Subject: FW: HVPC Reponse Planning application: Erection of detached dwelling at Springwood House, Sheffield Road, New Mill, Holmfirth HD9 7EX - 2020/93986
Date: 10 February 2021 12:06:04

Re. Springwood House

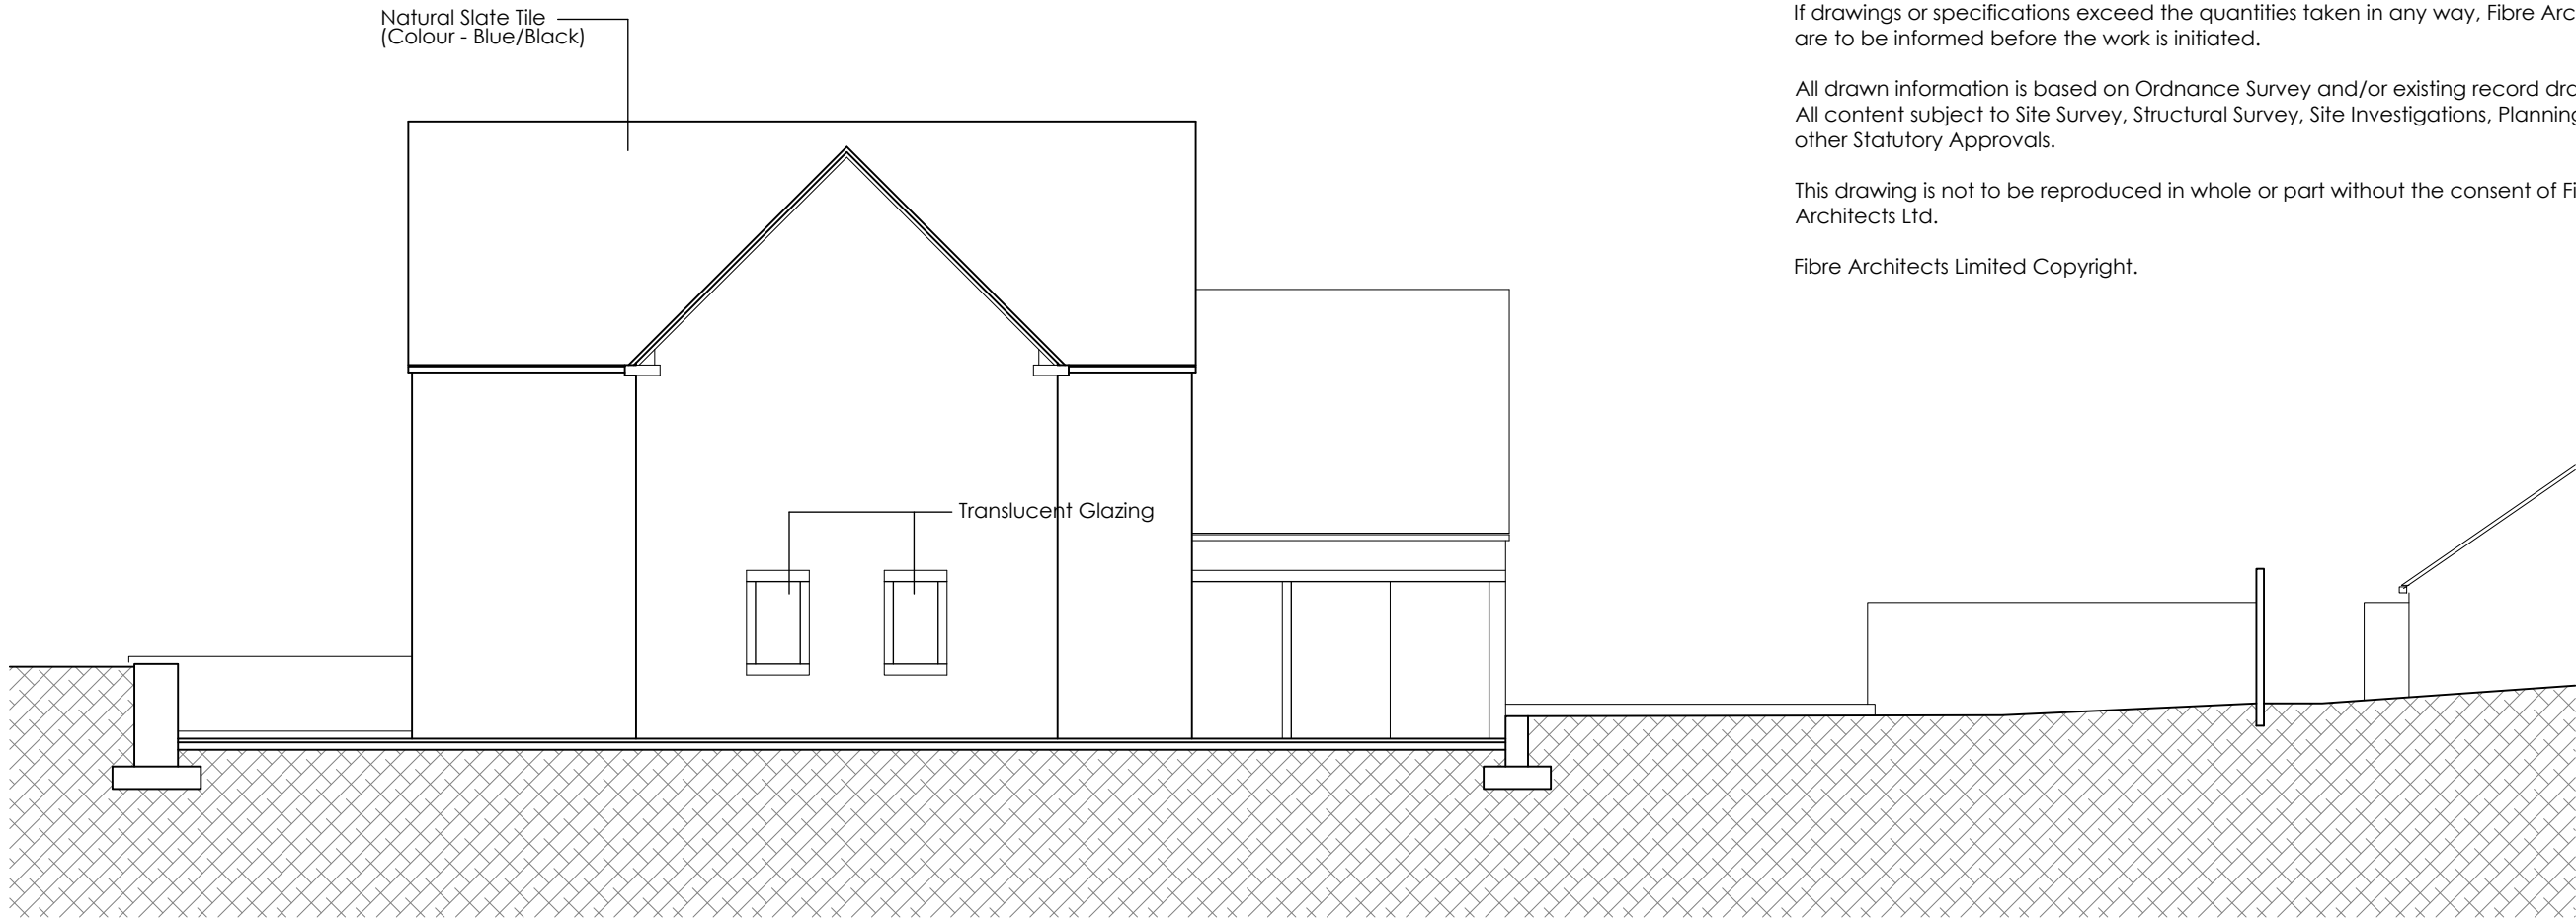
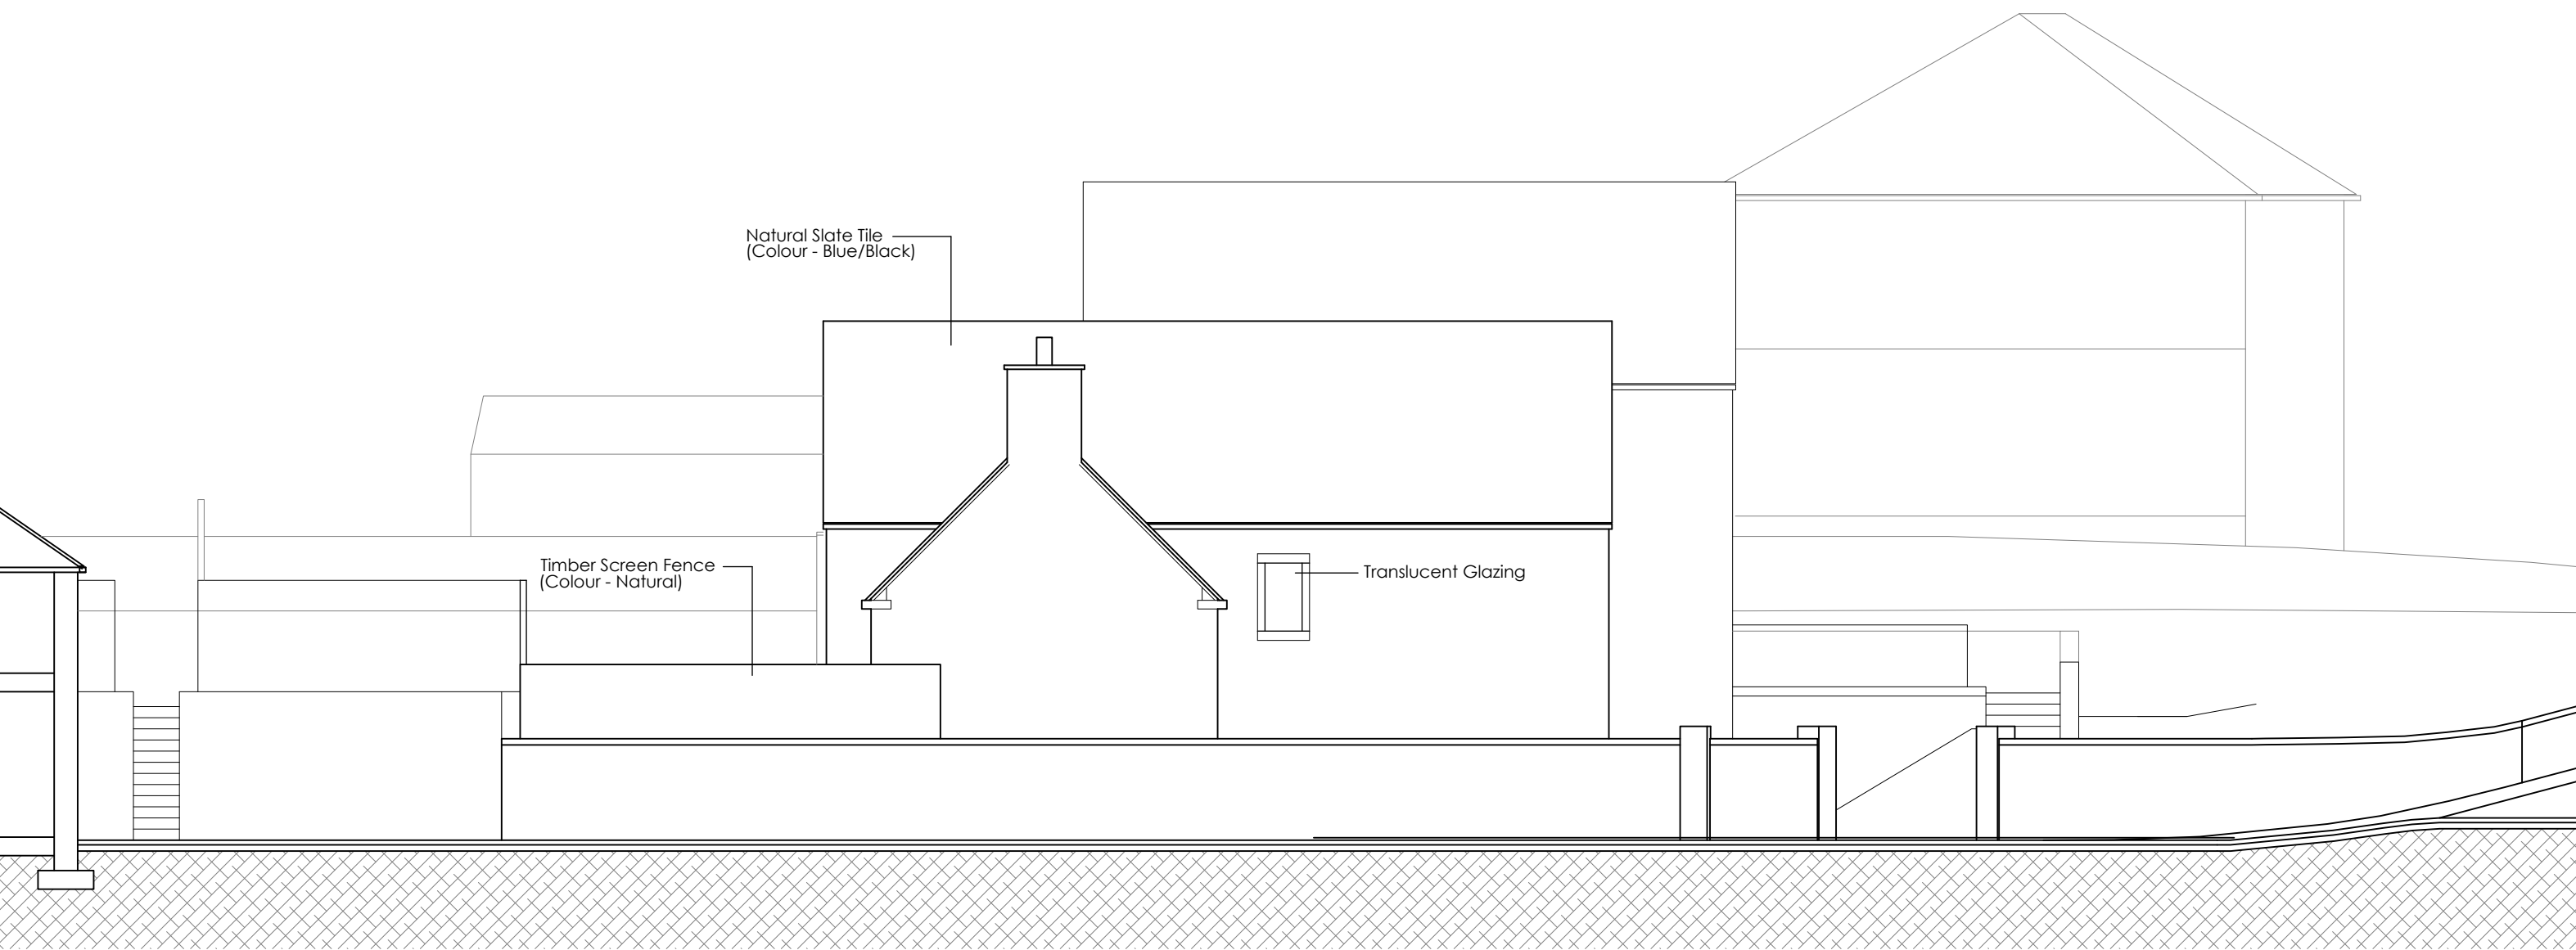
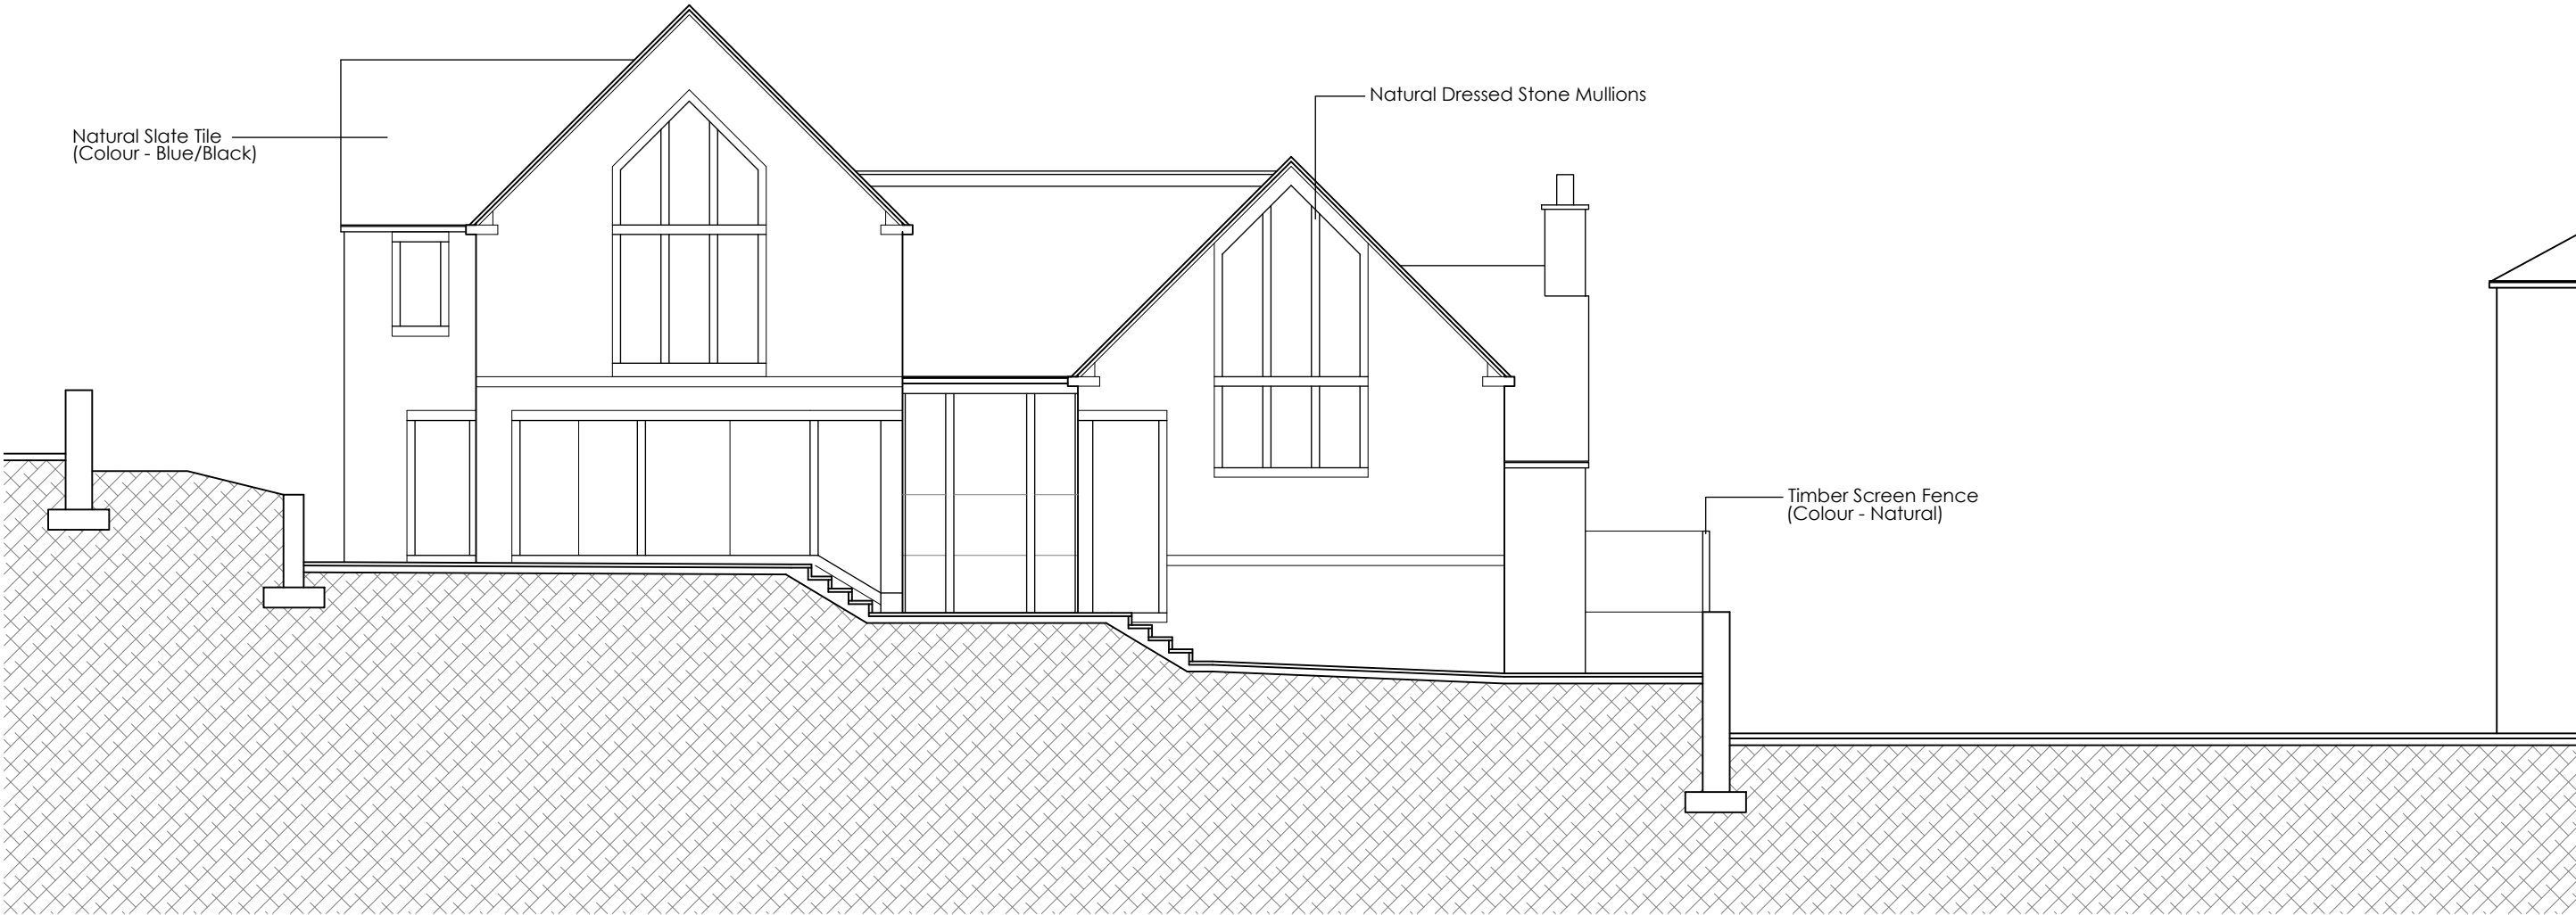
Holme Valley Parish Council's comment is: "Defer to Kirklees Planning Officers but they should acknowledge and address neighbours' concerns regarding overlooking and the height of the building."
